## Consultee Comments for Application 2025/92674

Application Number: 2025/92674

Address: land north of Denby Lane, Grange Moor, Huddersfield, WF4 4BH

Proposal: Discharge of details reserved by conditions 3 (finished floor levels), 4 (garage details) 7 (remediation strategy), 10 (CEMP), 11 (CEMP: Biodiversity), 12 (drainage), 13 (storm events), 14 (temporary surface water drainage), 15 (surface water attenuation), 16 (road condition survey), 17 (carbon emissions), 19 (materials), 24 (estate street phasing), 26 (waste plan), 29 (cycle parking), 31 (bin storage), 32 (electric car charging point), 33 (boundary treatments) and 34 (crime protection measures) of previous permission 2024/92444 for erection of 21 dwellings and associated works with means of access from Denby Lane

Revision notes			Revision notes			Revision notes			Date		PROJECT	
Rev.	Date	Notes	Rev.	Date	Notes	Rev.	Date	Notes	20.07.25	Whitwell Hill, Birmingham	Drawing Number	Revision:
-	-	-	-	-	-	-	-	-	Scale: 1:50	2400-002-001	-	-
-	-	-	-	-	-	-	-	-	Drawn By:	CP	Issuing Title:	TYPICAL CYCLE STORE DETAIL

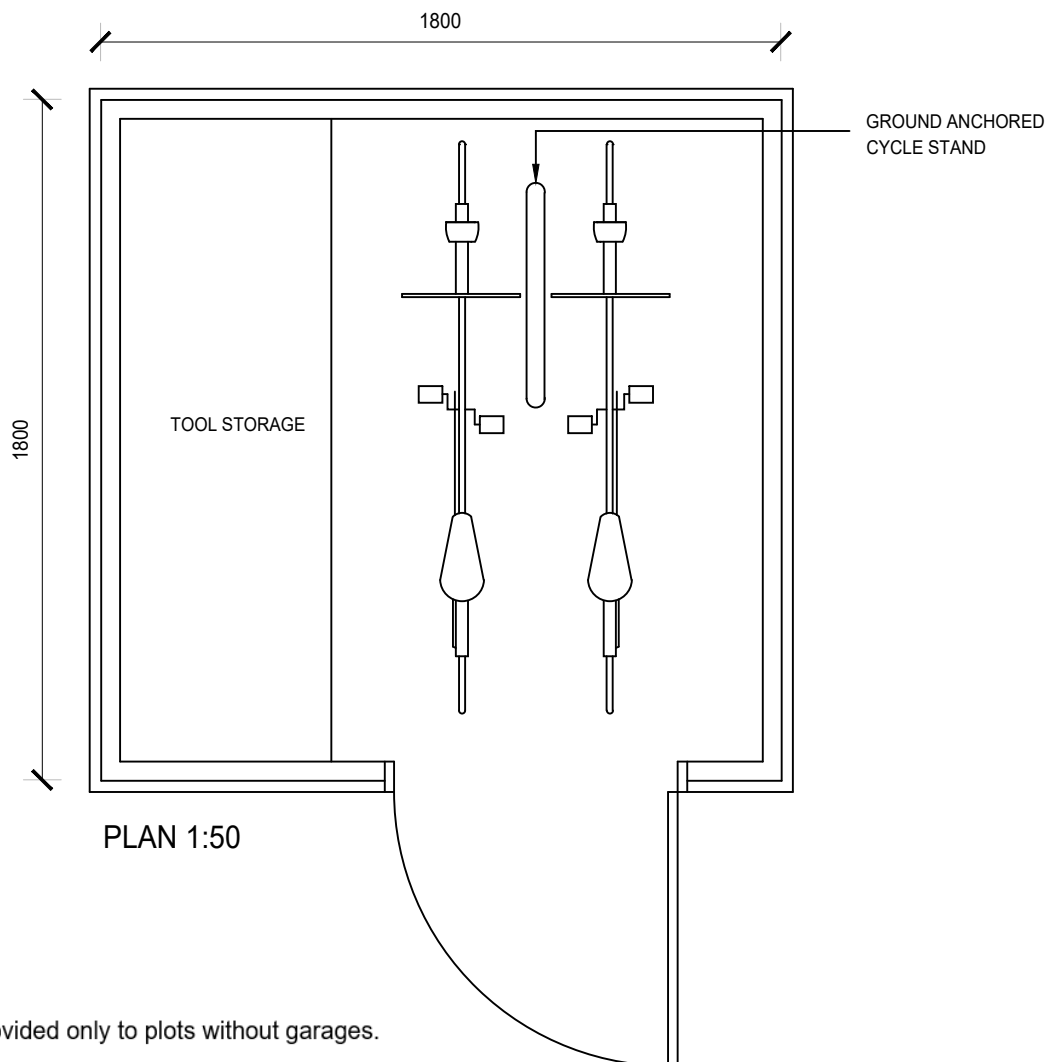
The shed does not contain any windows which is supported. It is recommended that the cycle stand is rated to Sold Secure Bronze as a minimum and door hinges reinforced with coach bolts for extra security.

Could the applicant confirm if there is any scope to implement the above measures, please?
